Awel y Môr Offshore Wind Farm

Comments on Submissions Received at Deadline 3a

Date: 30 January 2023

Document Reference: 4.4

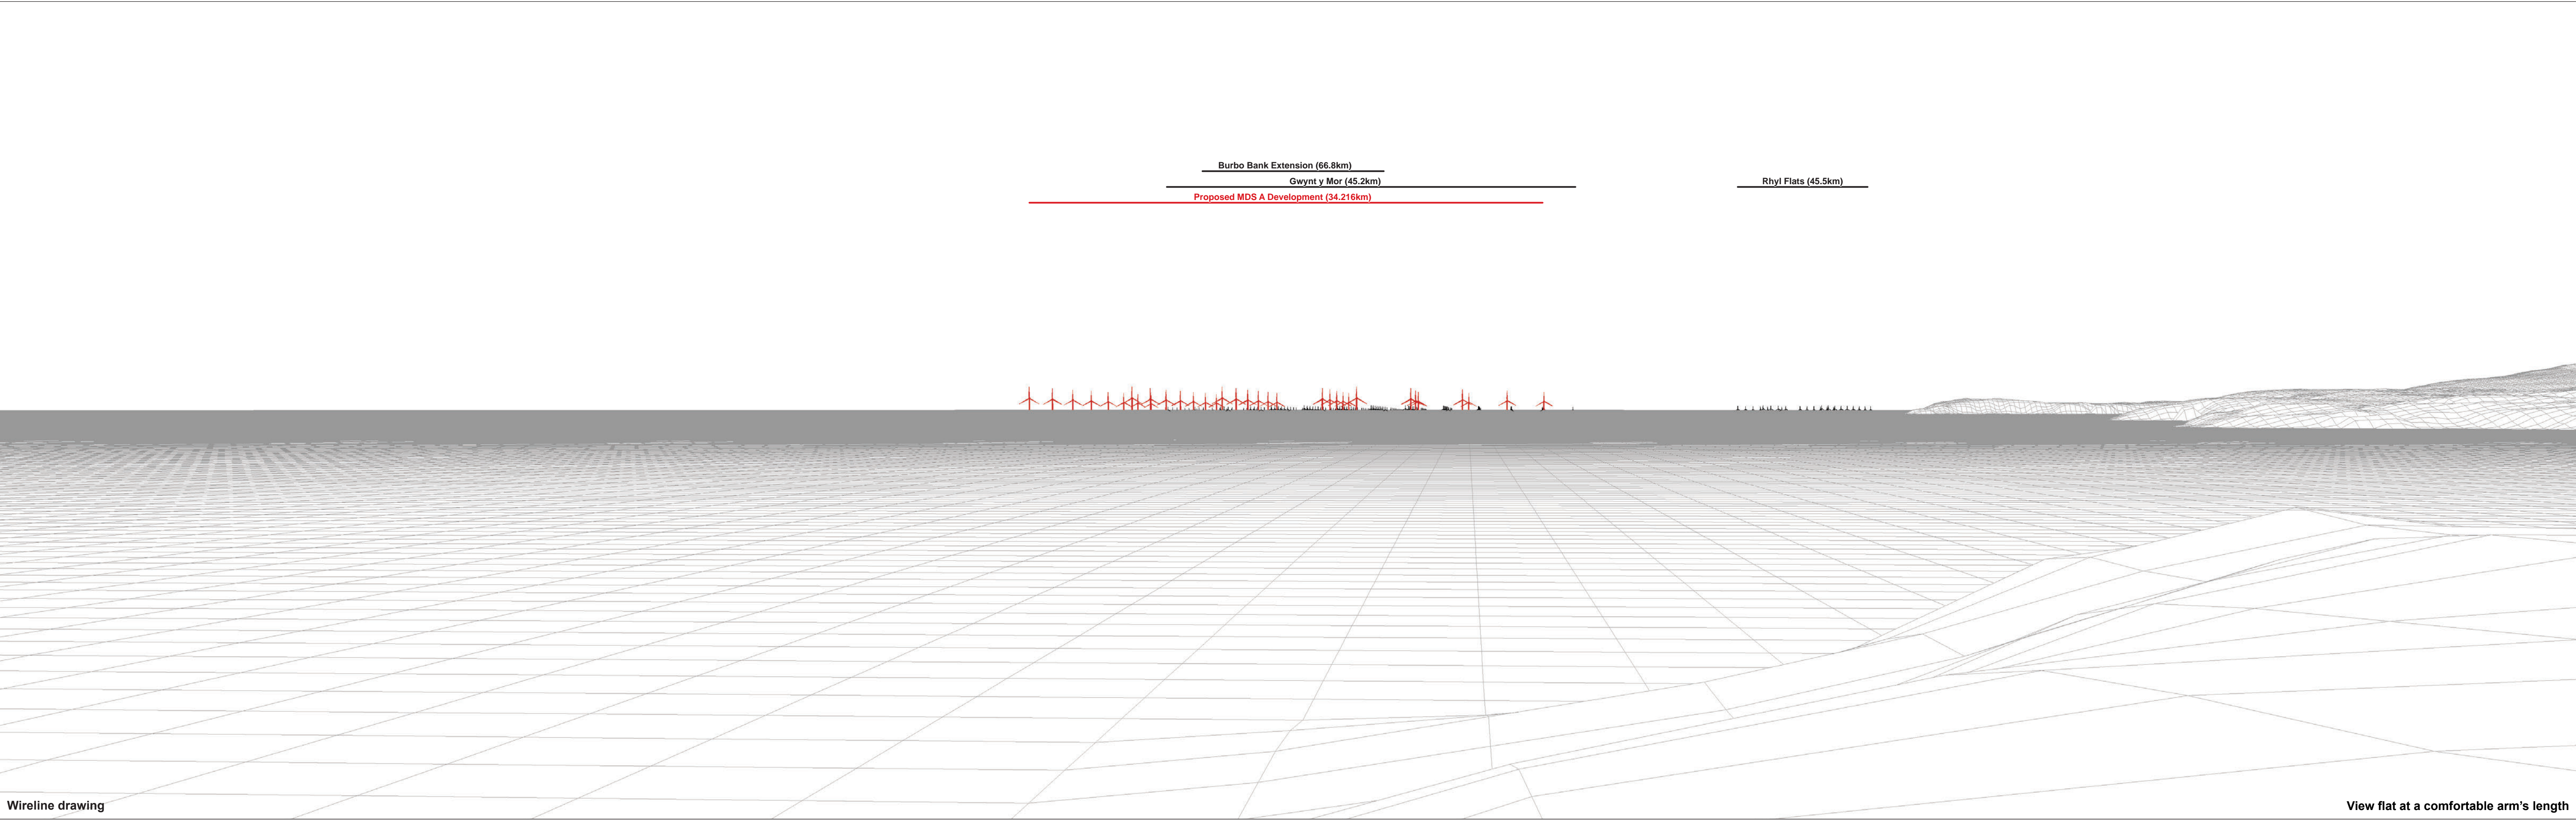
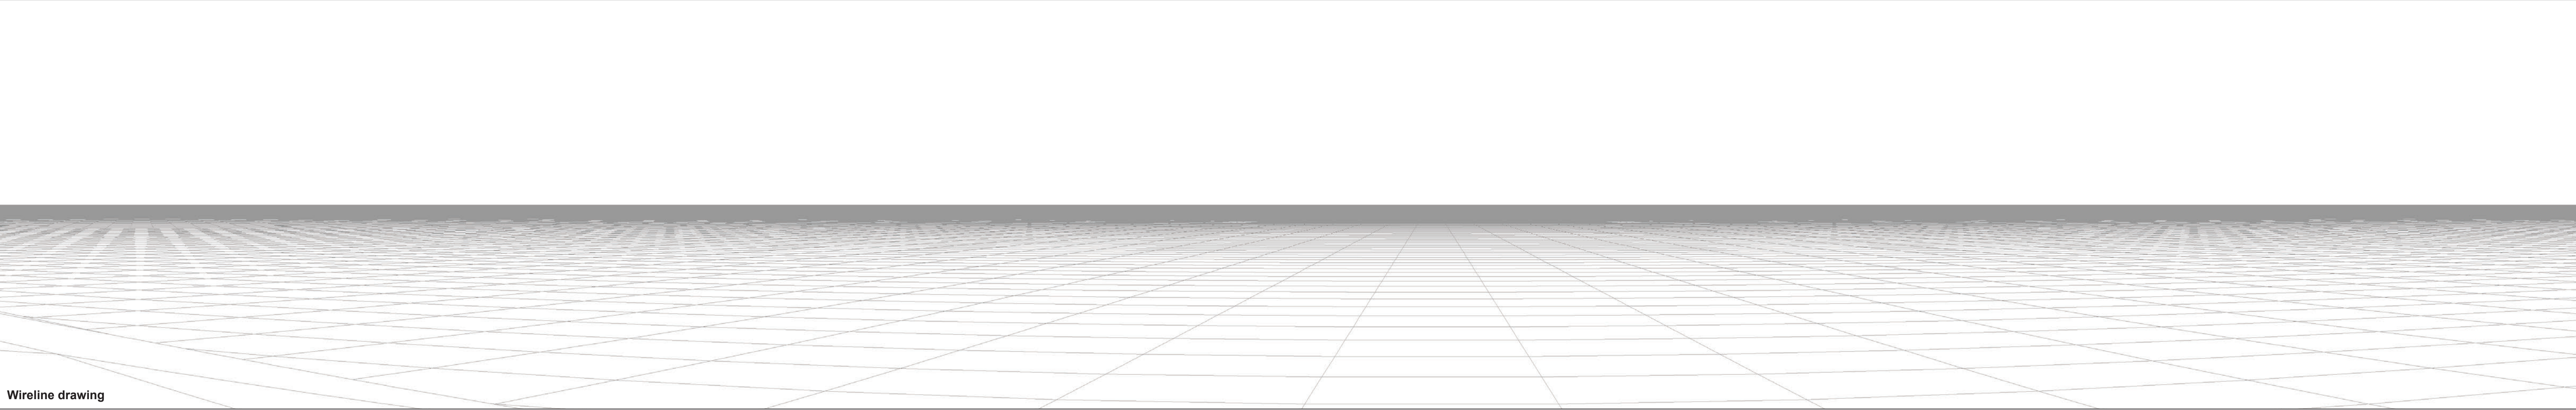
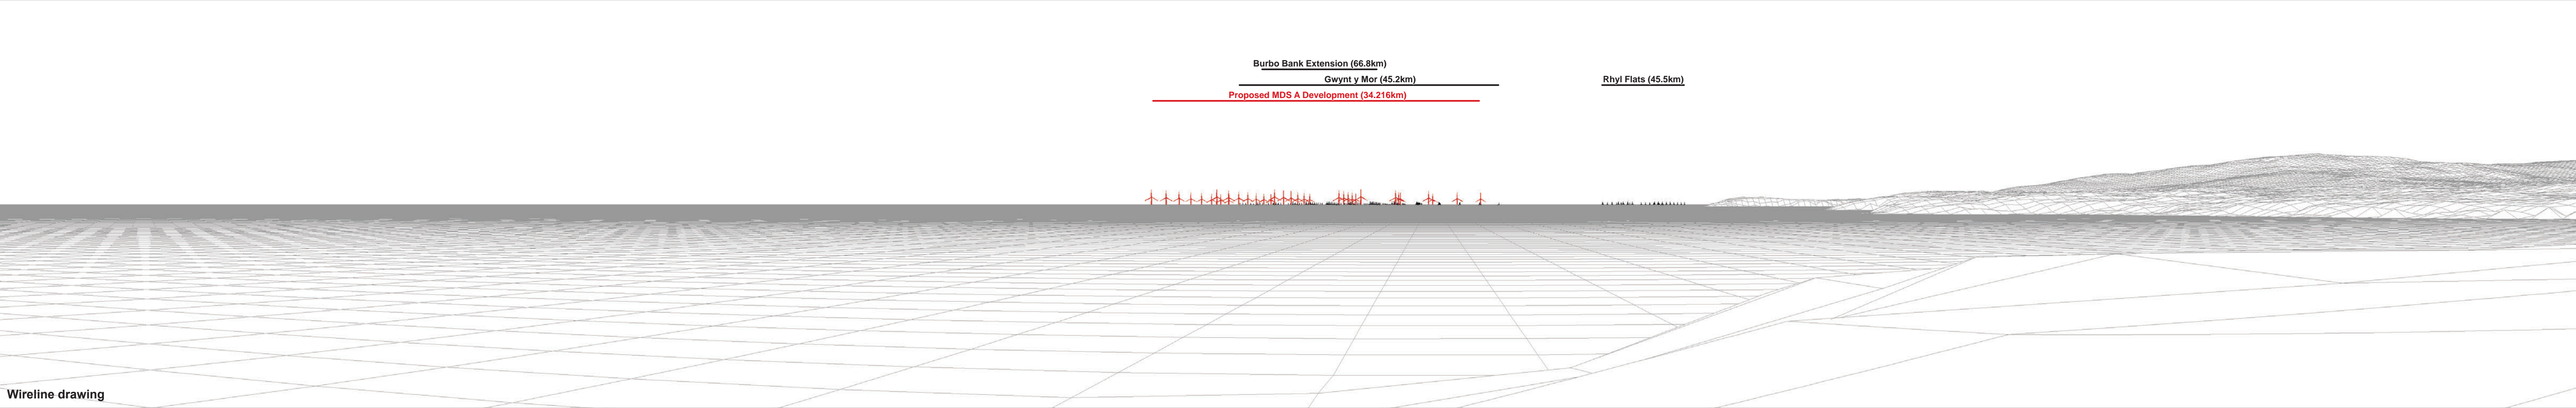
REP3a-021-2.5	<p>- Assessment of Viewpoints</p> <p>In relation to viewpoints (VP) 1 (Porth Llechog/Bull Bay) [APP-230], VP2 (Trwyn y Balog/ Point Lynas) [APP-231] and VP3 (Mynydd Eilian) [APP-232], we consider that the effects at these viewpoints have been underestimated in the SLVIA. We consider the effects to be of low-medium magnitude, and that this level of magnitude combined with high sensitivity should lead to an assessment of moderate adverse effects, which we consider significant. We consider the threshold for significance has been reached for VPs 1, 2 and 3.</p>	<p>As detailed in the Applicant's Written Summary of Oral Submissions (REP3a-004), whilst it is agreed that AyM would be a new component of these views, it is not considered that the effects would be of such magnitude as to make them significant.</p> <p>The SLVIA considers the effects on viewpoints 1, 2 and 3 in table 6 of the SLVIA (AS-027). The high sensitivity of the receptors is acknowledged therein with the assessments also considering the extent of the wide open views affected, the location of AyM relative to the wide open seas and the degree of existing development that effects the views, which is acknowledged does not include offshore wind farms.</p>

REP3a-021-2.6	<p>From these viewpoints, highly sensitive receptors (e.g., walkers on the coastal path) are focused on the coastal landscape and sea views. Although there are large-scale sea views, the scale and nature of the development would make it very noticeable and focus attention upon it. Sea views and the coastline are the key focus of views in the predominantly coastal AONB and sea views are currently untrammelled by development or any other significant human activity, apart from the occasional ship. This part of the AONB is relatively remote and tranquil. The existing offshore windfarms to the east, including Gwynt y Môr, are extremely hard to discern even in fine weather and built development along the coastline is not similar in nature or scale to the proposed wind farm. The proposal would interfere with the appreciation of the open sea and coastline including views of coastal landforms and the mountains of Eryri (Snowdonia). Windfarms</p>	<p>The Applicant considers that although the turbines would be noticeable in the seascape, the magnitude of change would be low and the effects would not be significant based on professional judgement.</p> <p>Professional judgement on the significance of the effects or otherwise must be applied by viewing the visualisations at the viewpoints where the wide open seas, that would remain a key characteristic of the views, can be properly appreciated The Applicant also considers that the extent of AyM as a minor part of the overall seascape should be considered.</p>
